KITTITAS COUNTY FIRE MARSHAL'S OFFICE

May 29, 2013

Re: Willard Short Plat

After conducting a review of the above named project, I have the following comments:

WILLARD LOT 2 SHORT PLAT
 PART OF SECTION 25, T. 18 N., R. 18 E., W.M.
 KITTITAS COUNTY, WASHINGTON

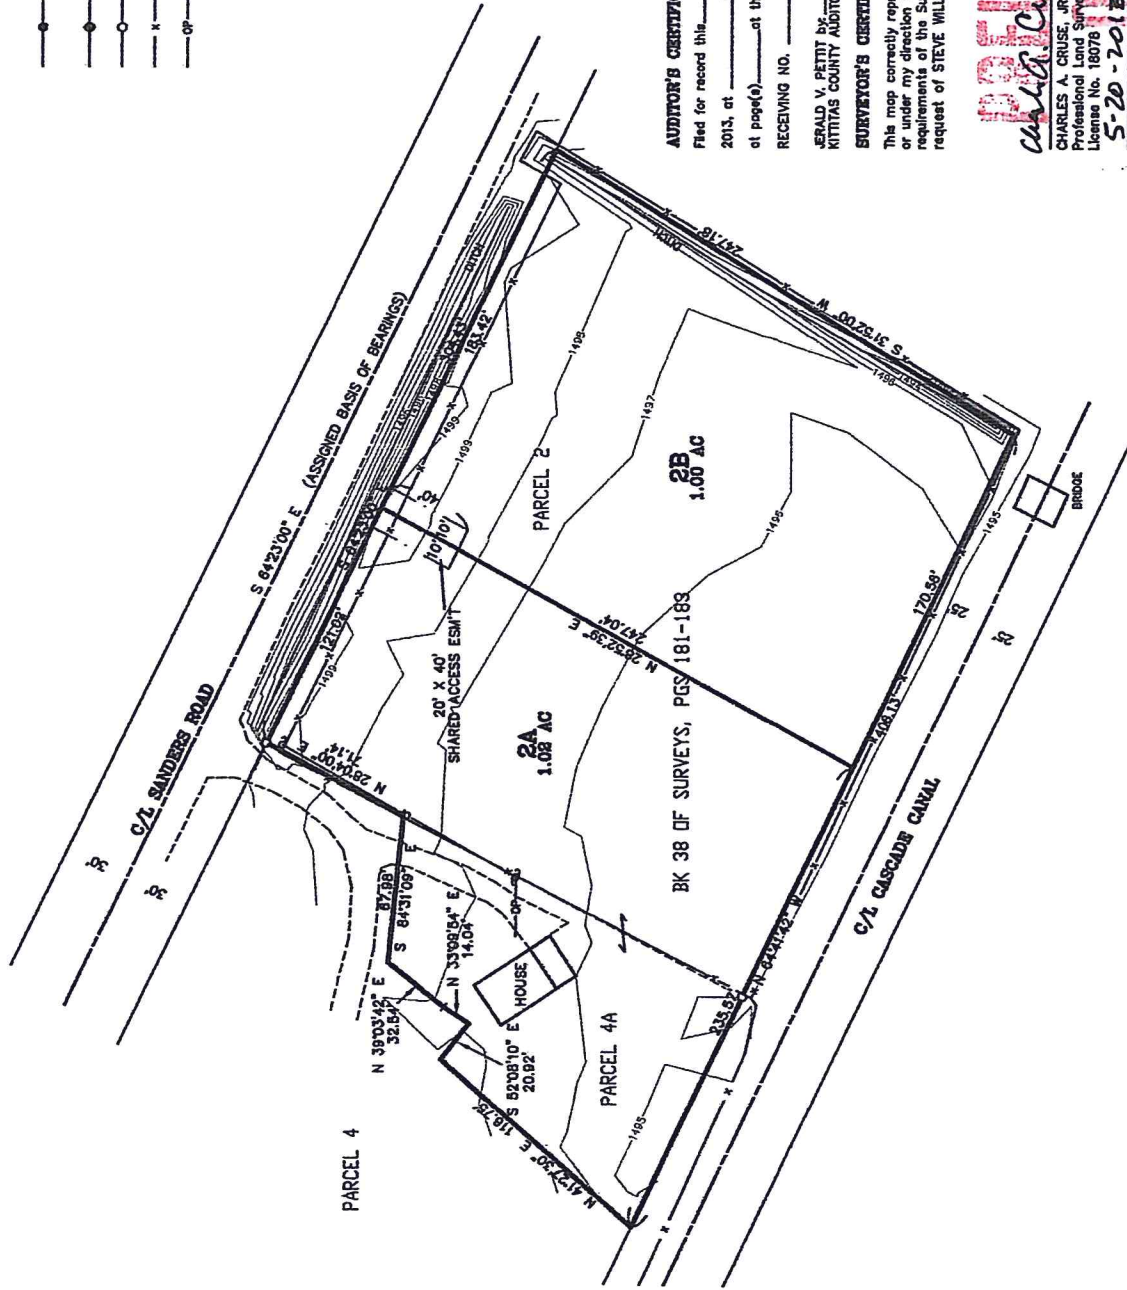
- The driveway(s) for the new property must comply with Kittitas County Code, i.e. any driveway greater in length than 150' shall be no less than 16 feet in width.
- The addresses shall be posted at the front of the property and easily visible to emergency responders.
- All future development must comply with the International Fire Code.
